OEH Science Division

Review of Springvale and Angus Place Mine Extension EISs

# Predicted Profiles of Conventional Subsidence, Tilt and Curvature along Prediction Line A1 Resulting from the Extraction of LW1001 to LW1019

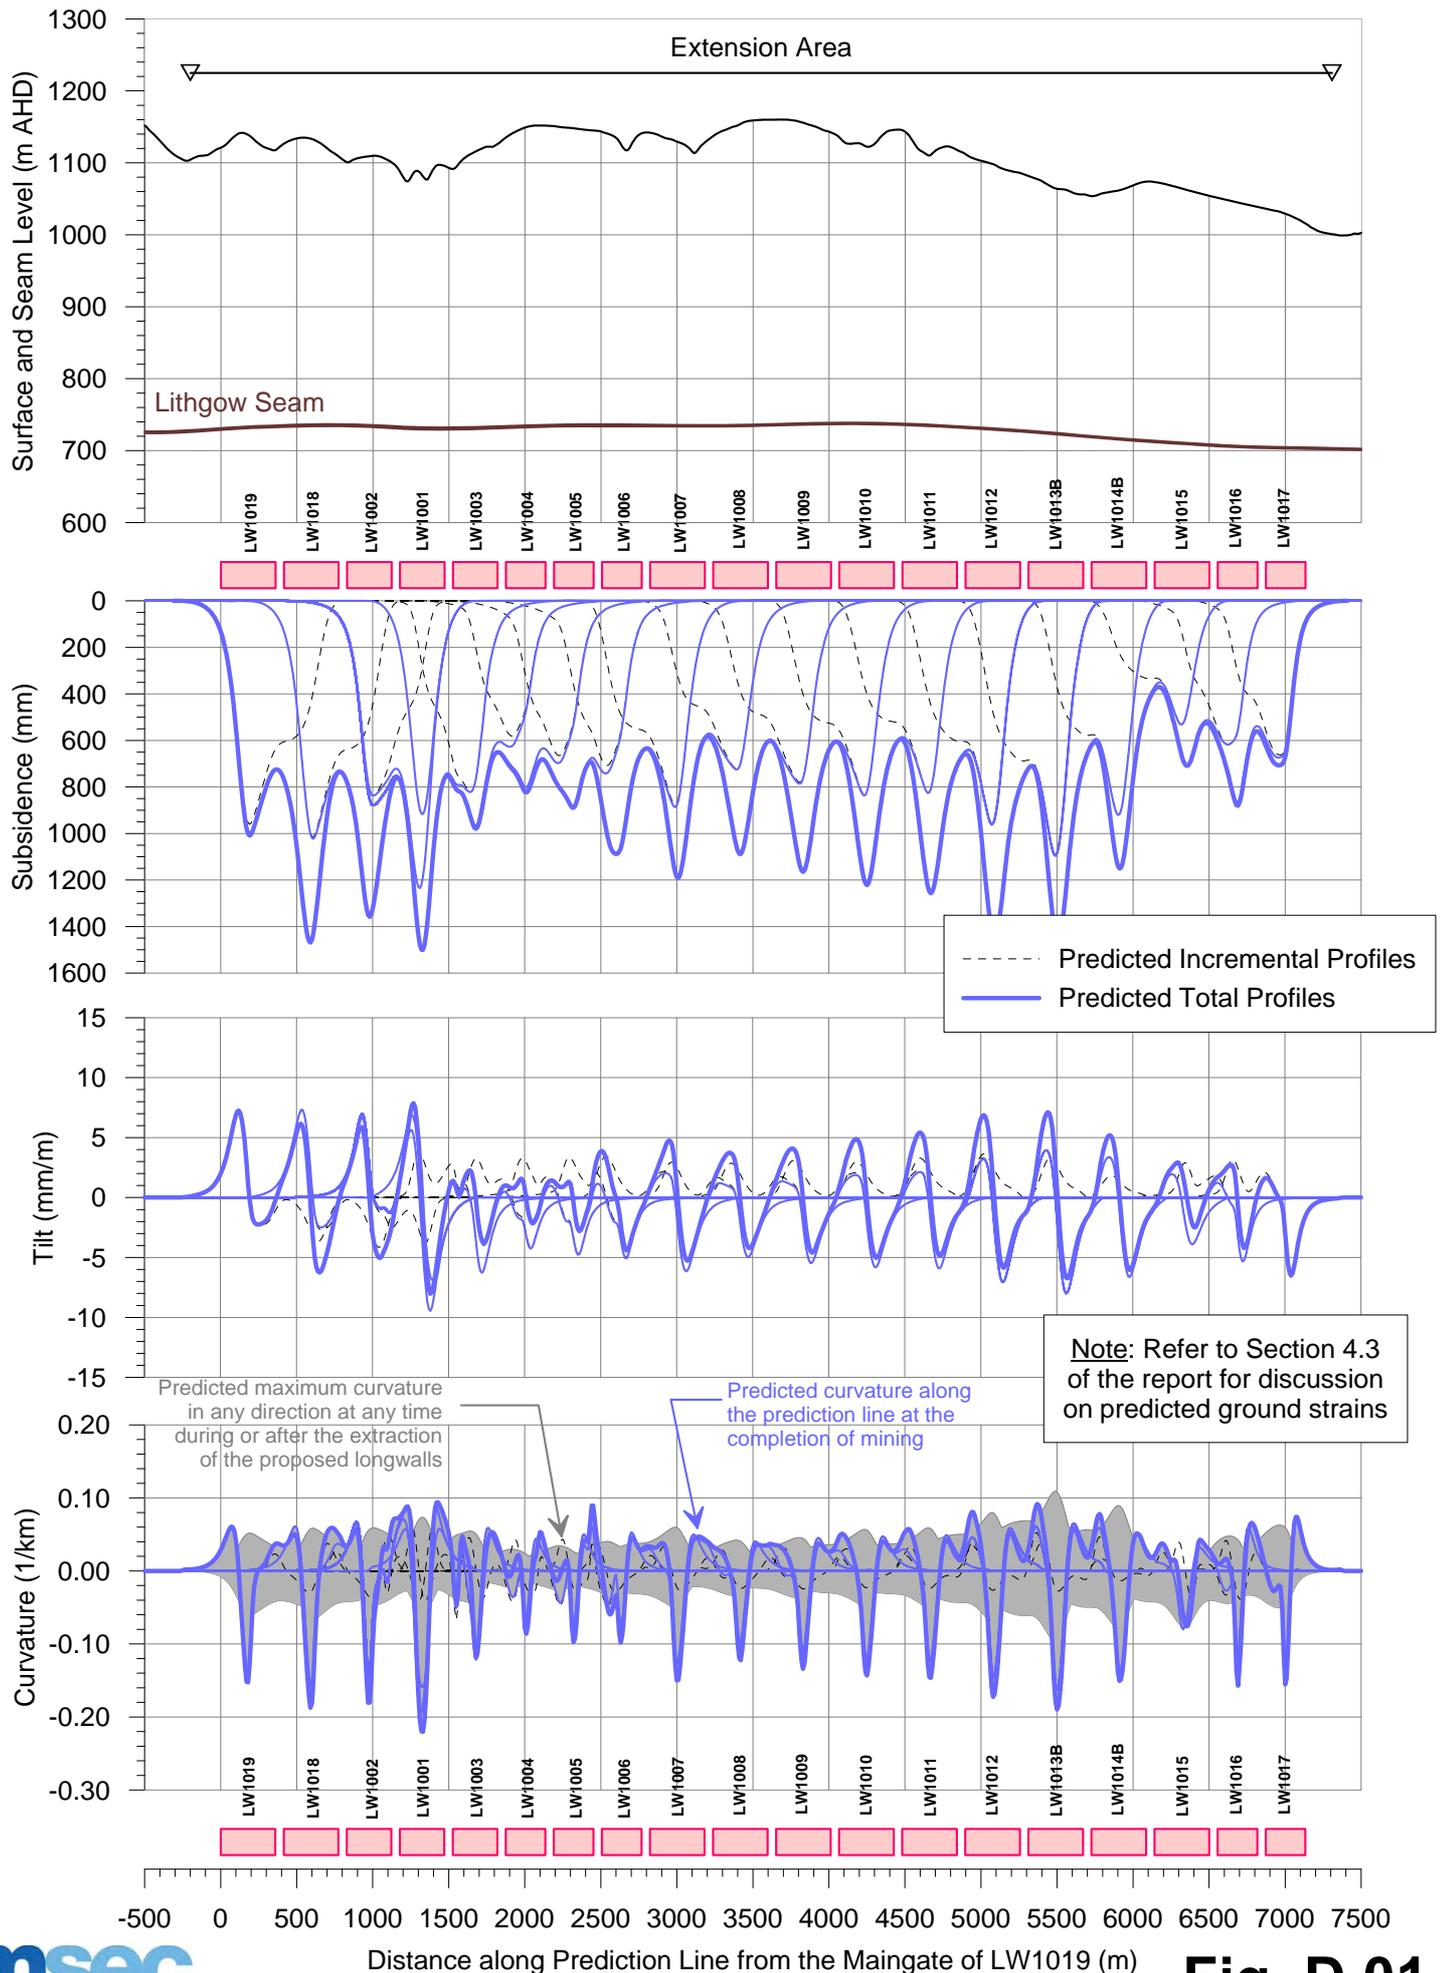
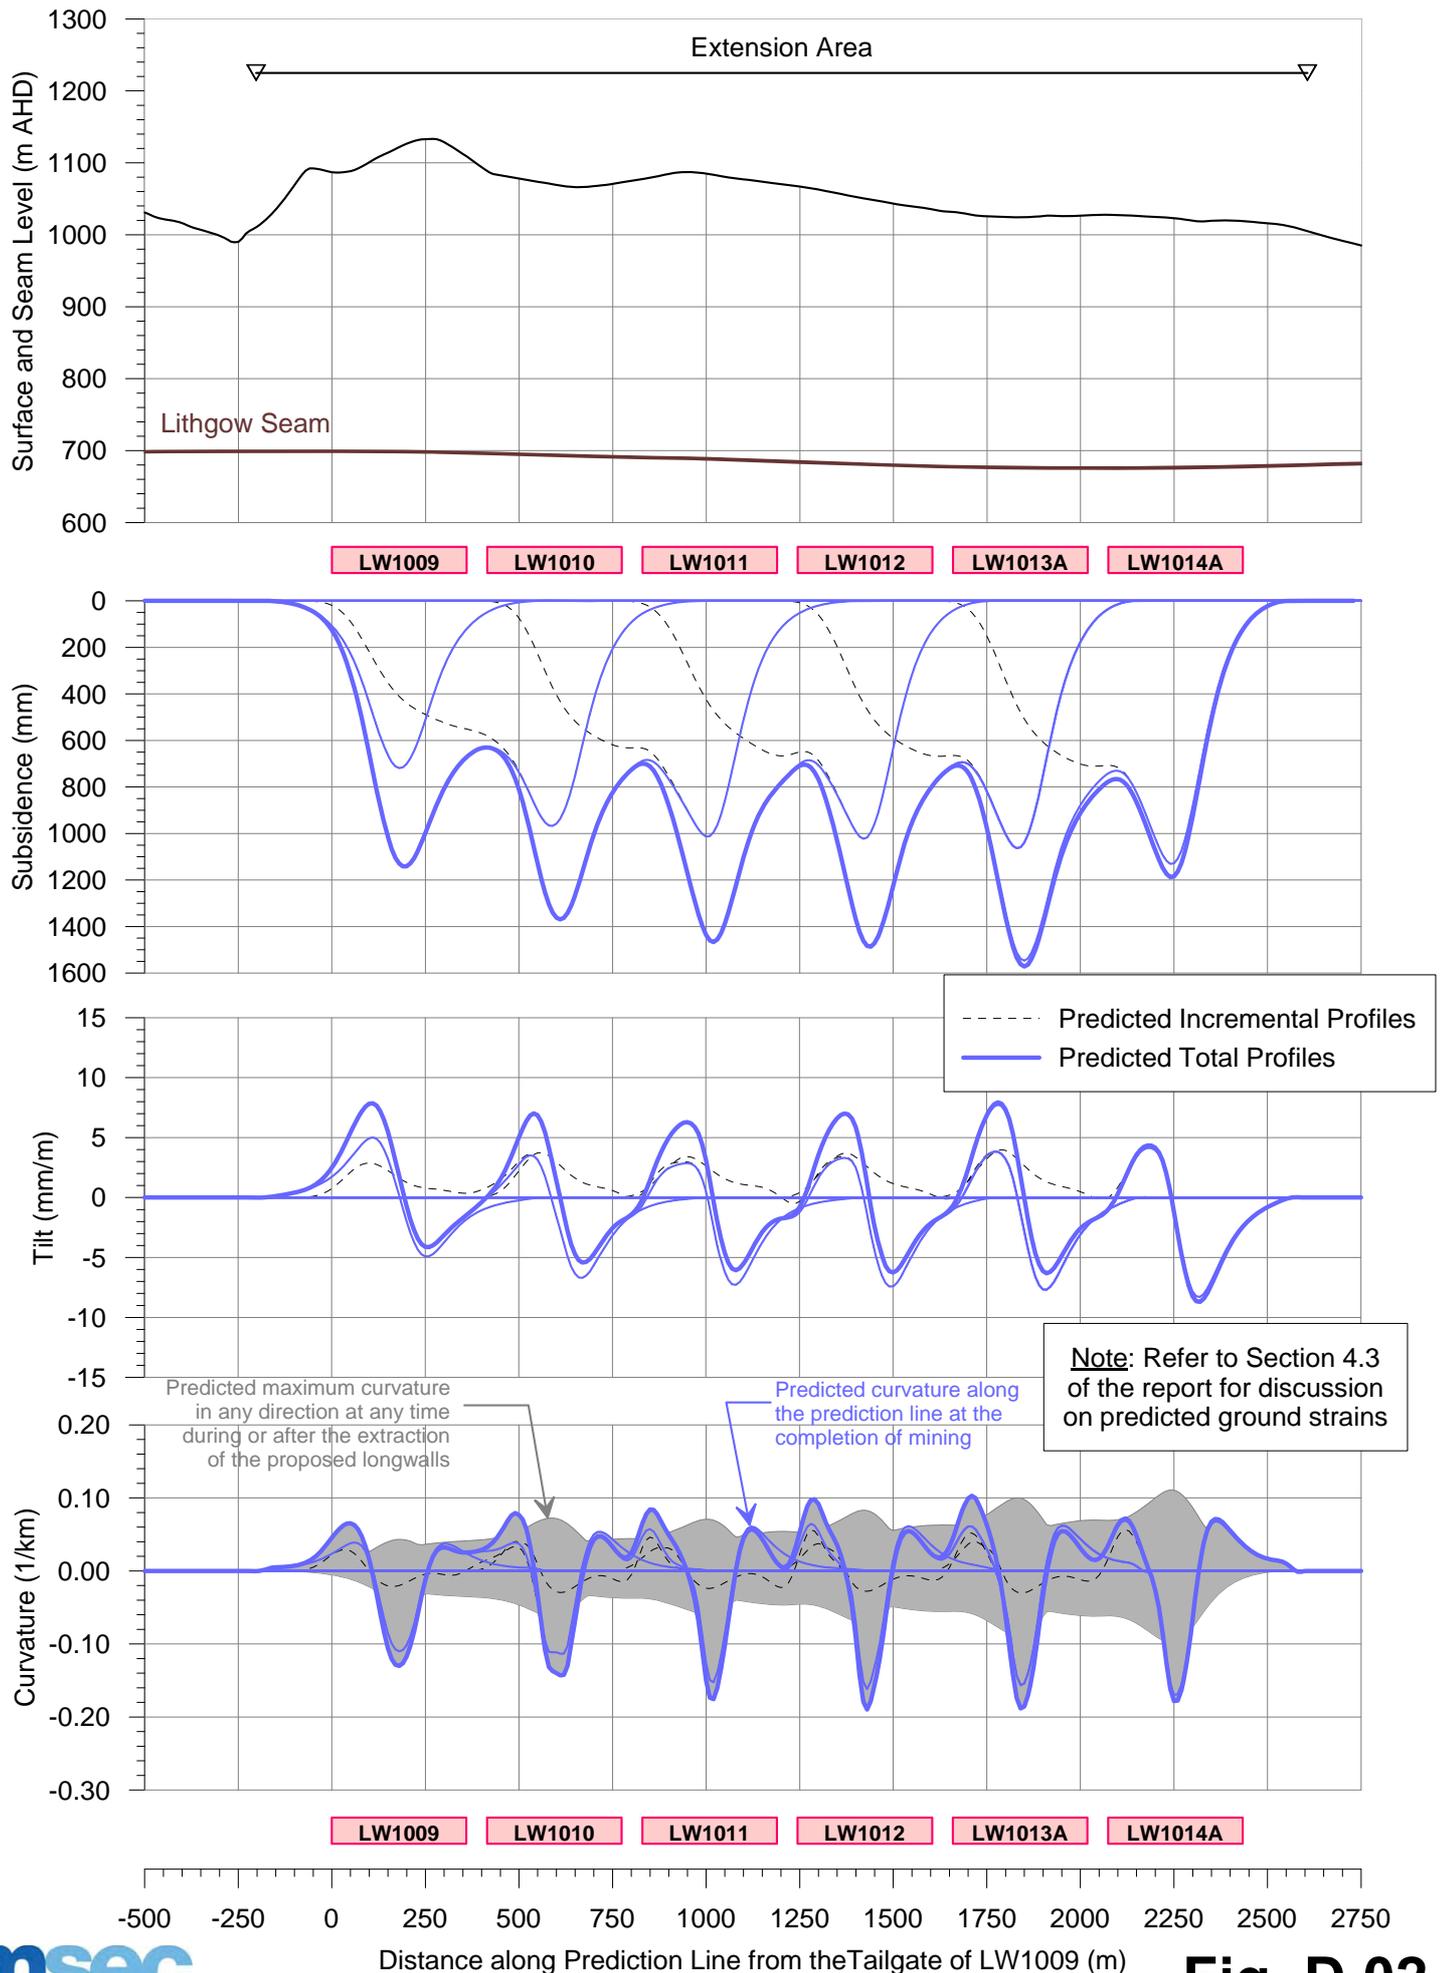
predictions lines for Angus Place (A1 & A2) appear to miss the majority of incised drainage lines and steep slopes that lie above the proposed Angus Place mine.

DATE: 2-Apr-2014	SCALE: 1:40000	DRAWING No: MSEC593-07	Rev No C
---------------------	-------------------	---------------------------	-------------

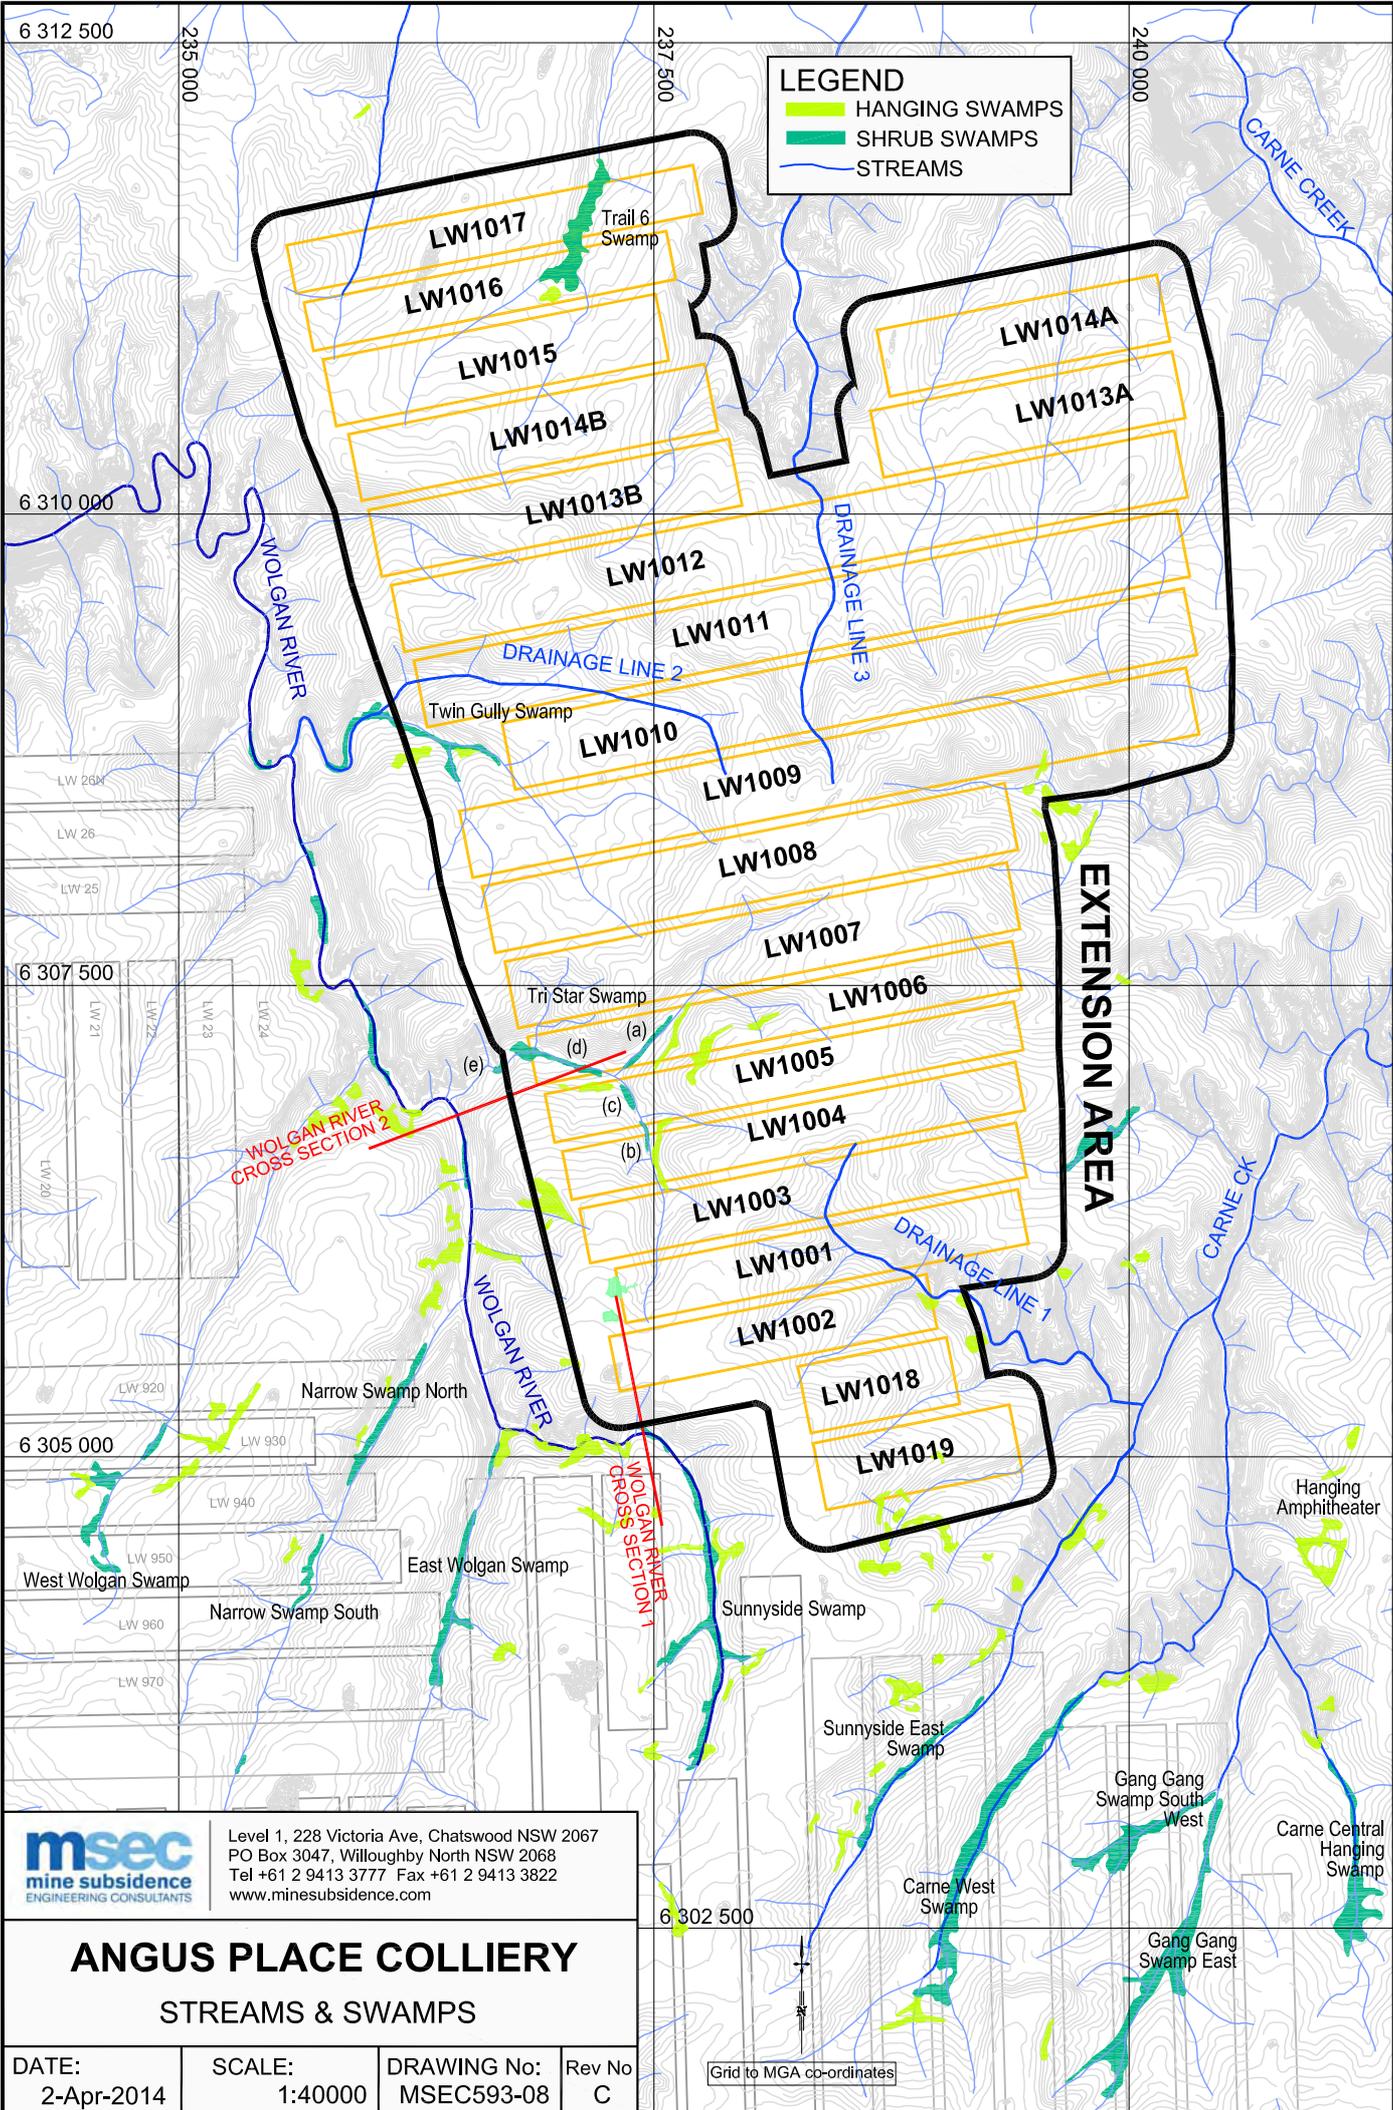
Type 1 and Type 2 geological structure zones have been identified within the Extension Area, which are shown in Drawing No. MSEC593-07. It is expected, that locally increased subsidence and compressive strains will be observed in these locations.
